Office of
Environment
& Heritage

Your reference: MP11_0082
Our reference: Doc12/45111
Contact: Belinda Leo, 9995 6820

Exhibition of Environmental Assessment for commercial development at Murray Rose Avenue (formerly 7 Parkview Drive), Sydney Olympic Park (SOPA) (MP11_0082)

PROJECT TITLE
3 MURRAY ROSE AVENUE
SYDNEY OLYMPIC PARK
DRAWING TITLE
Demolition Plan

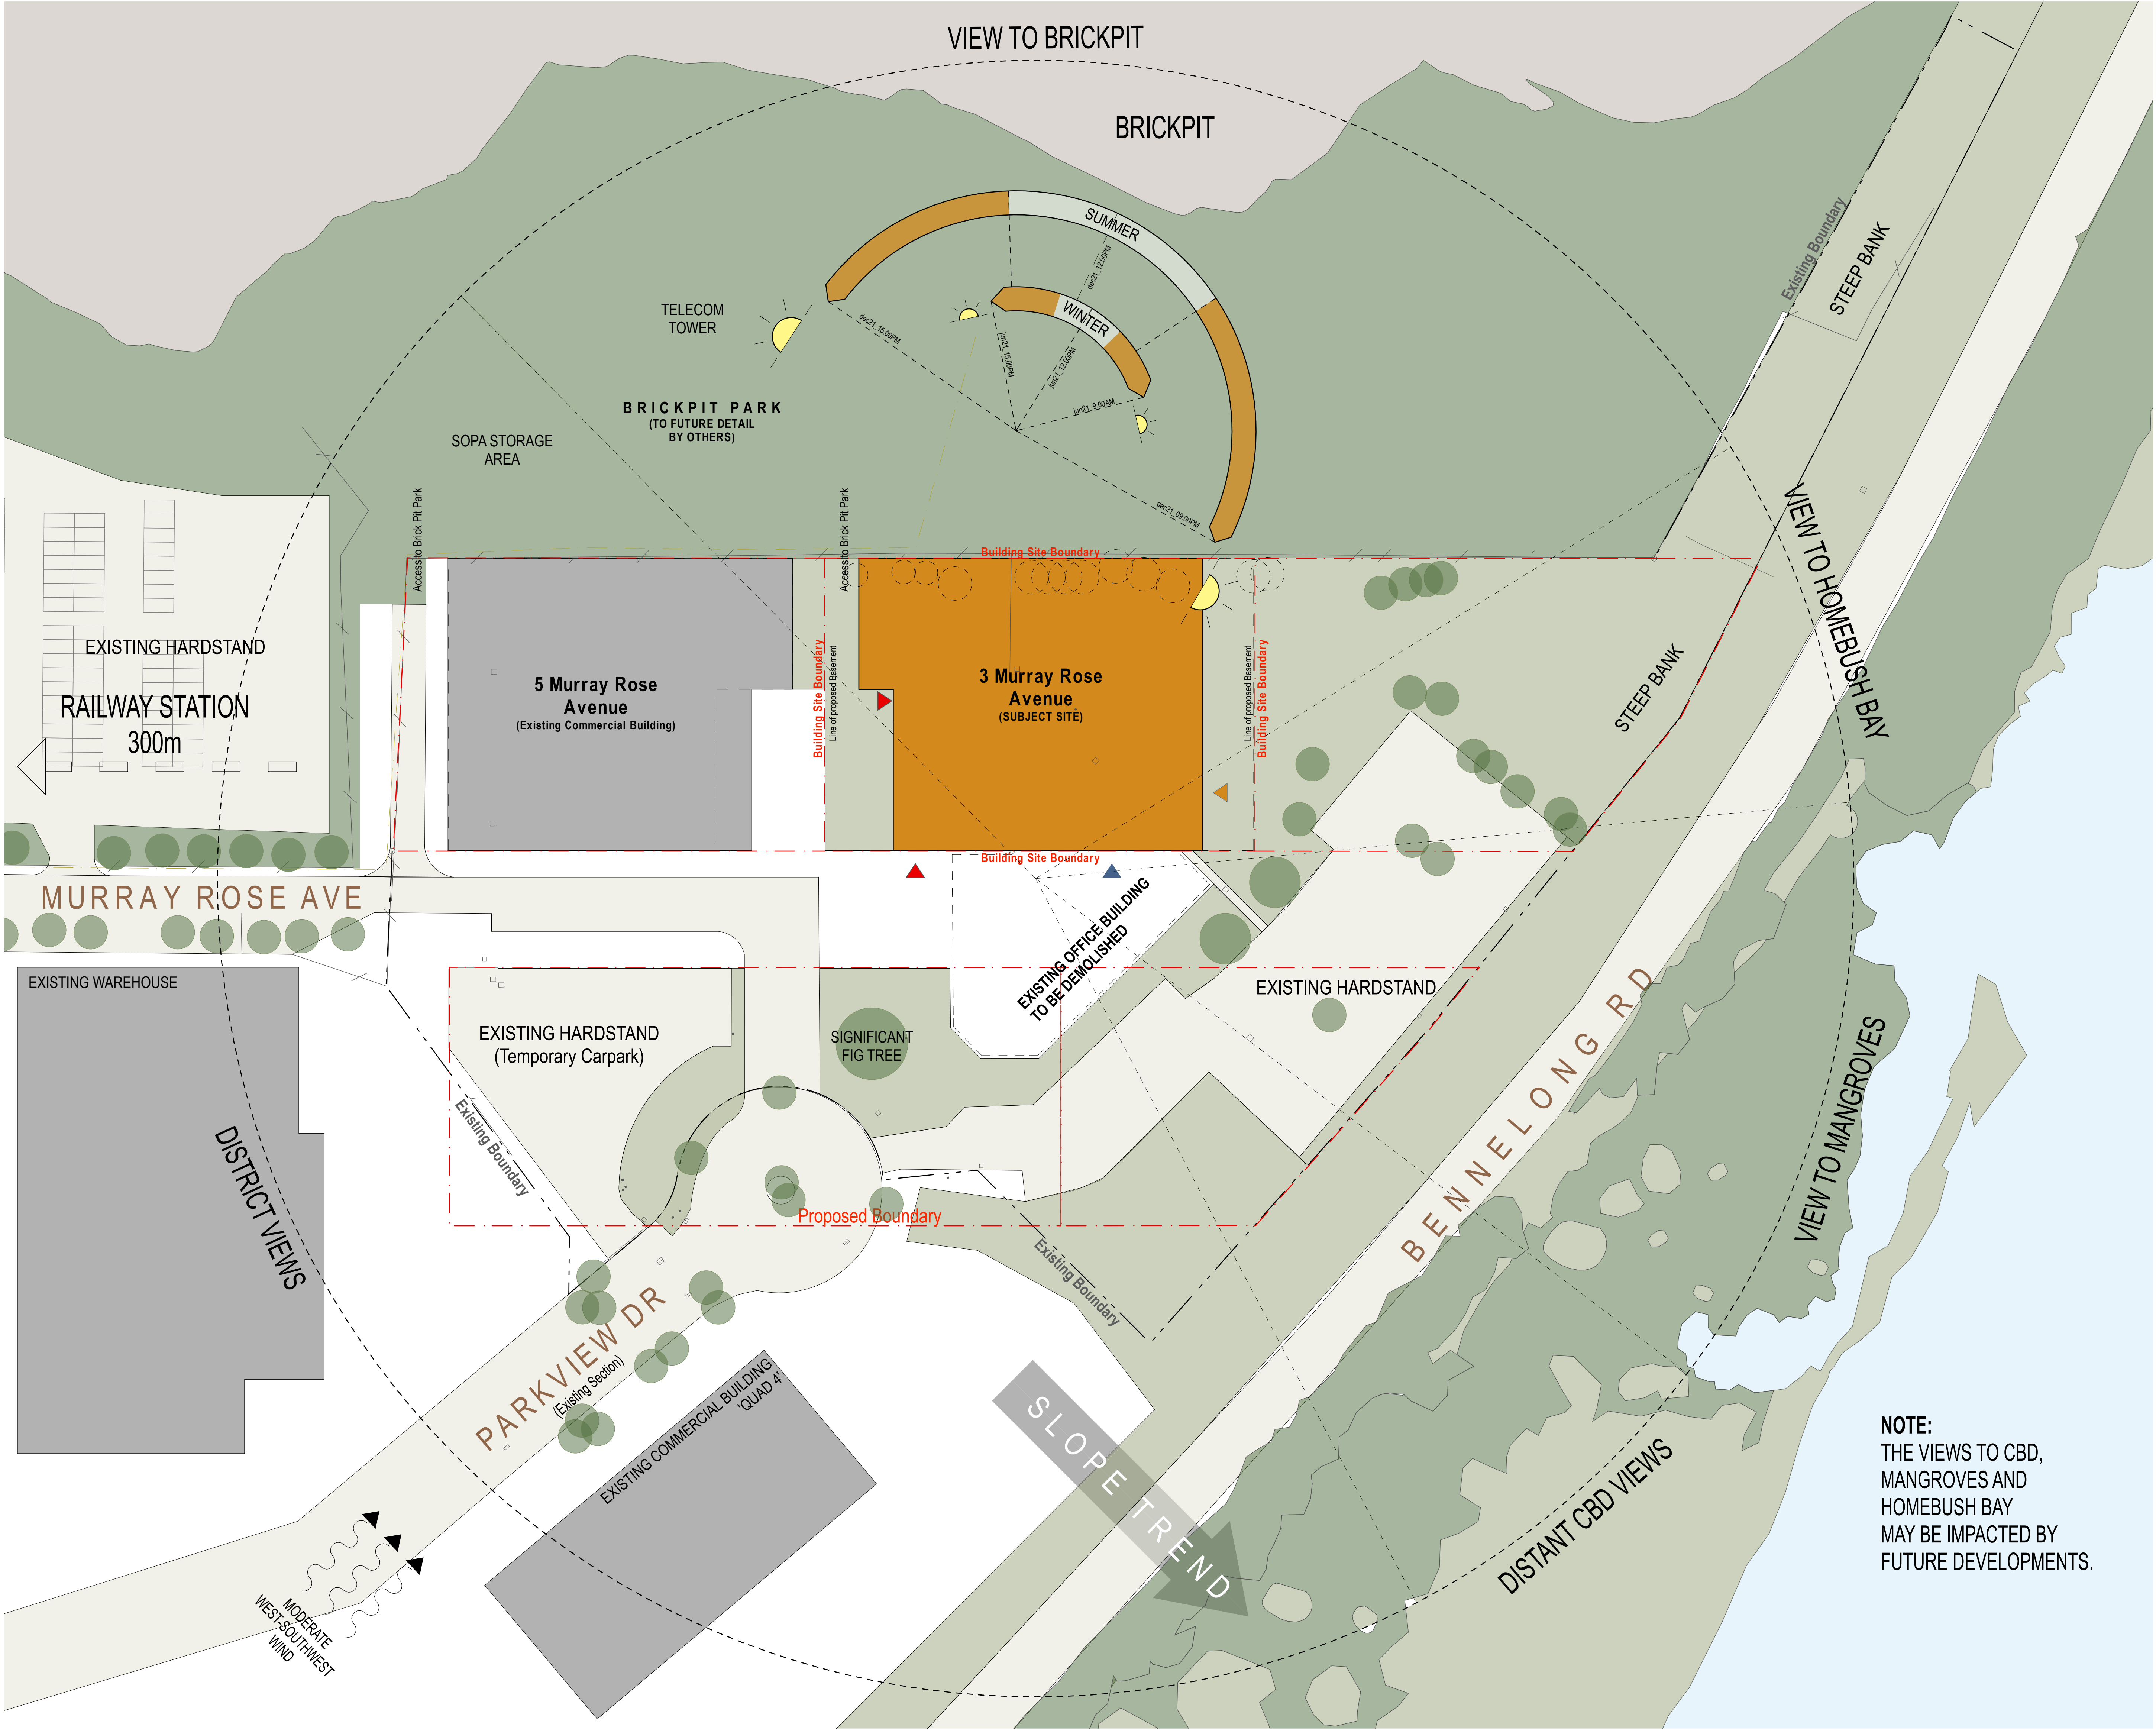
The Environmental Assessment Report states that the proposal will lead to the removal of a Lilly Pilly hedge (*Syzygium* sp.). OEH notes that the threatened plant species, *Syzygium paniculatum*, is often used as a hedge species. OEH advises that the identification of the Lilly Pilly species should be confirmed, and if it is found to be *S. paniculatum*, then the impacts on this threatened species need to be adequately assessed (even though it has been planted).
